From: Joe Gilbert
Sent: Friday, September 20, 2013 7:15 AM
To: Jeff Watson
Cc: Erin Moore
Subject: RE: BL-13-00023 Haw

From: Jeff Watson
Sent: Thursday, September 19, 2013 12:13 PM
To: Christina Wollman; Brenda Larsen; Jan Ollivier; Holly Duncan; Erin Moore; Joe Gilbert
Subject: BL-13-00023 Haw

HAW GARAGE

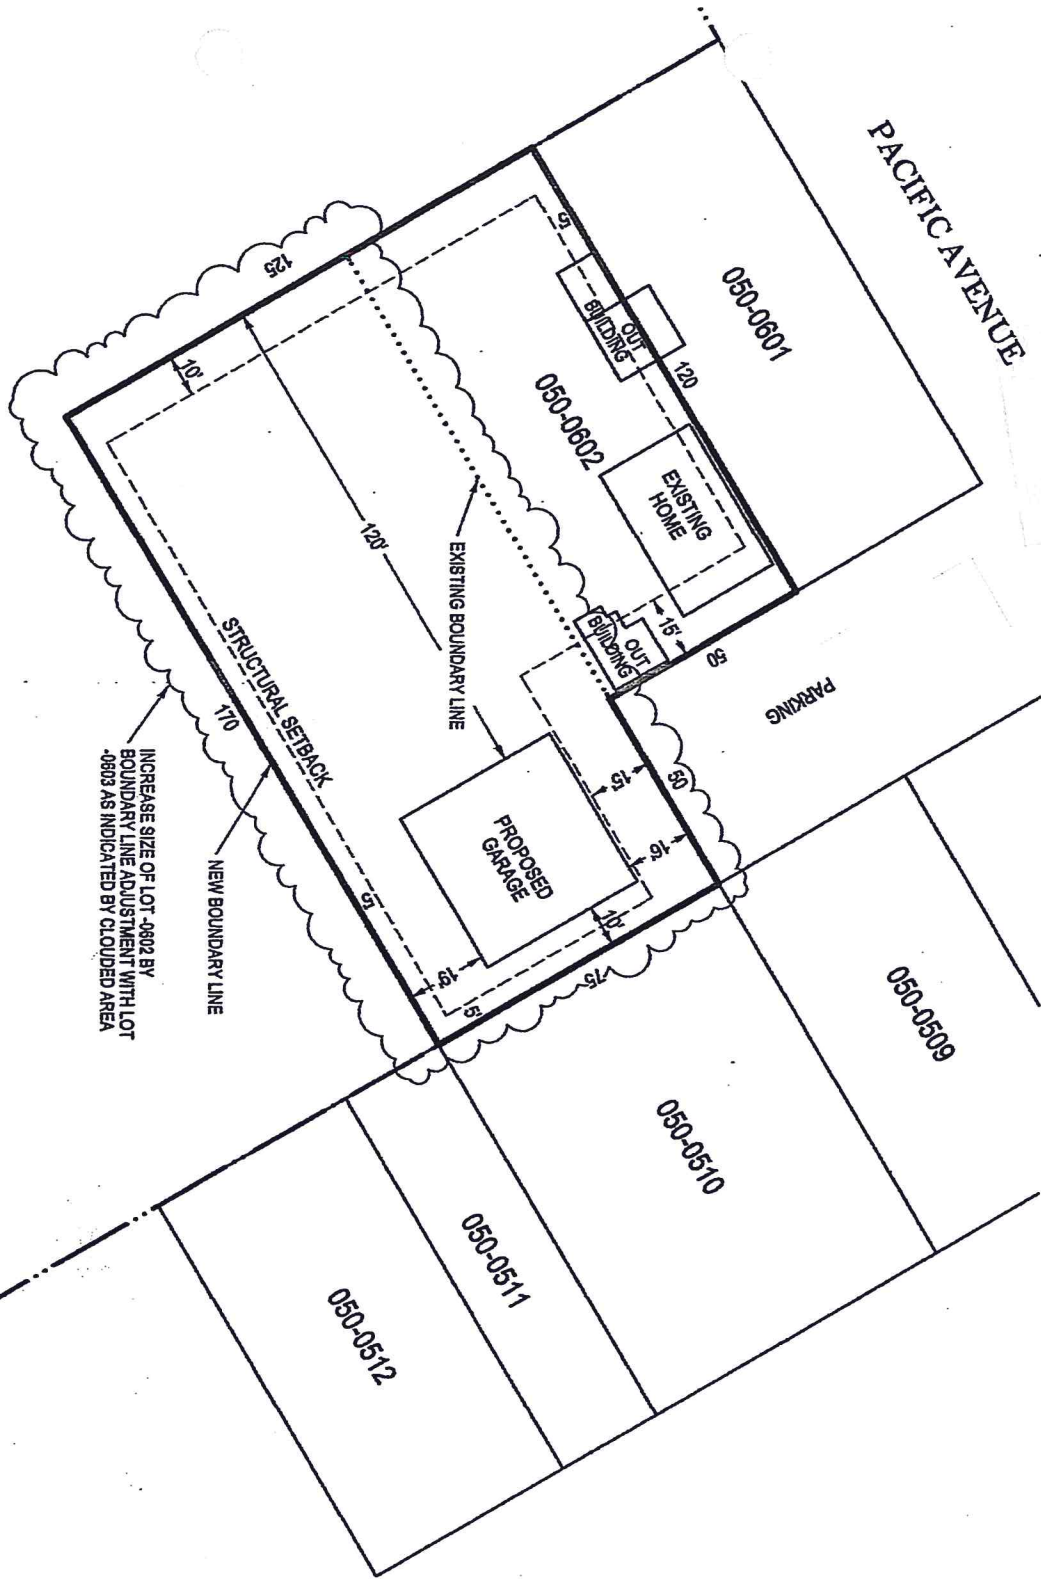
Being so closed to Ronald, I cannot determine whether the property is served by sewer and water from the city... I think there is a need for a section in the application that asks existing / proposed sewer and water source.

The site map makes no reference.
